Subject: RE: 22 Beach Road, Littlehampton.

Figure 7. Review of 1-hour periods inside Flat 1 bedroom

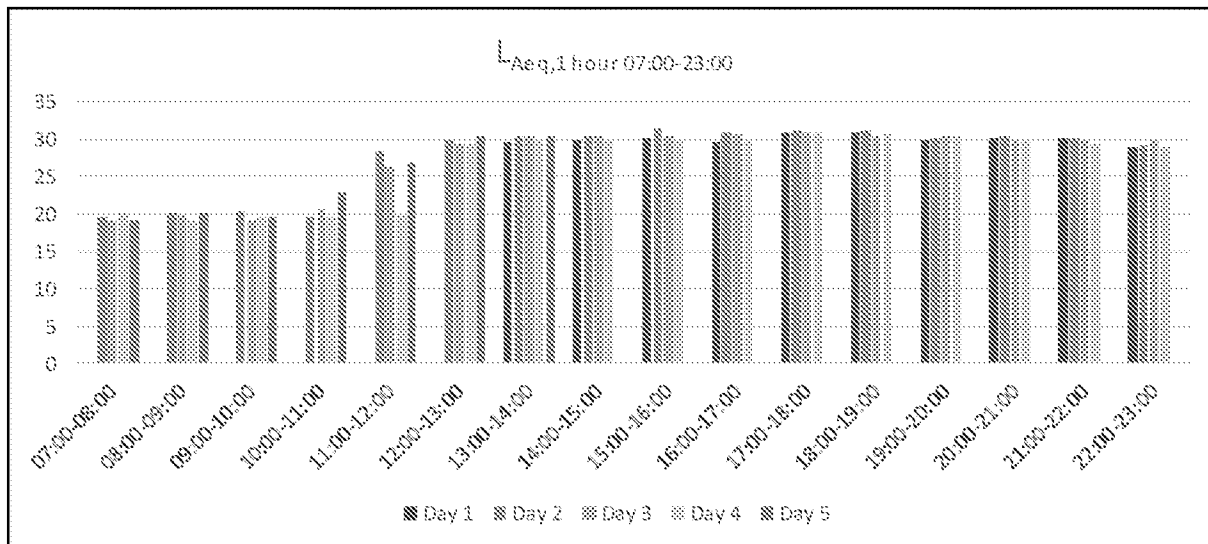
In respect of your report, 23rd August, page 3, paragraph 3 then to clarify, my comment related to **Figs 6 & 7** and **Flat 1** where daytime noise was found to be 28.8 with windows closed and therefore 39 to 44dB with reasonable adjustment for an open window.

Figures 6 and 7 in the report relate to Flat 1, however the references to 39 and 44dB relate to Flat 2, front bedroom, which is reported in Figure 10.
